Your Ref: OWPC18620
Our Ref: FG/85/18/A
Please ask for:
Mr A Wood

Town & Country Planning (Control of Advertisement) (England) Regulations 2007 (as amended)

1no.externally illuminated fascia sign & 2no. non-illuminated hanging signs
52-56 Ferring Street Ferring

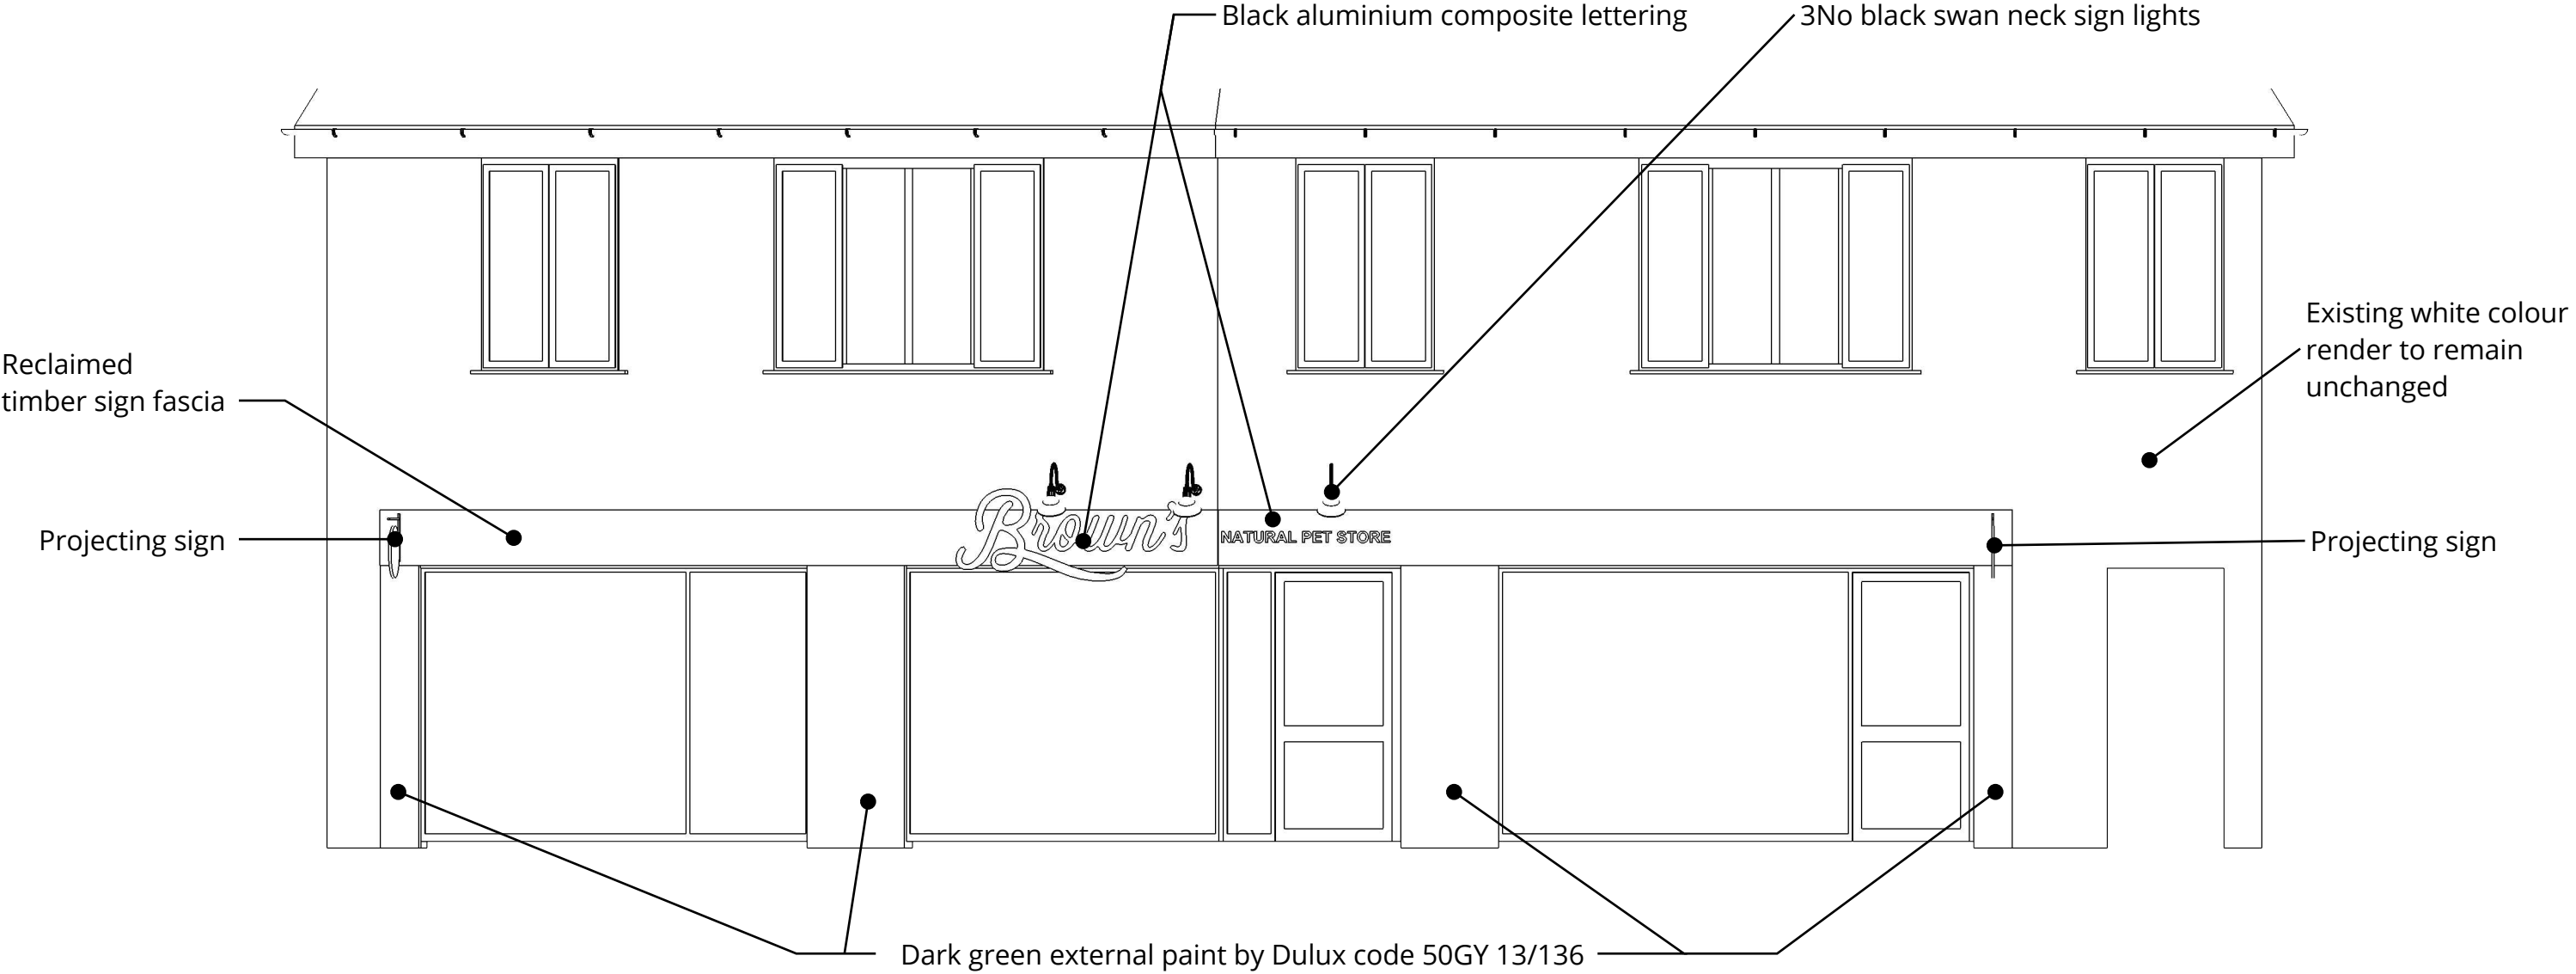
Ferring Parish Council recognises that the proposed illuminated sign is similar to the sign at Andulcia Restaurant.

Ferring Parish Council requests that there is a condition on the application that the illuminated sign is switched off when the premises closes in the evening.
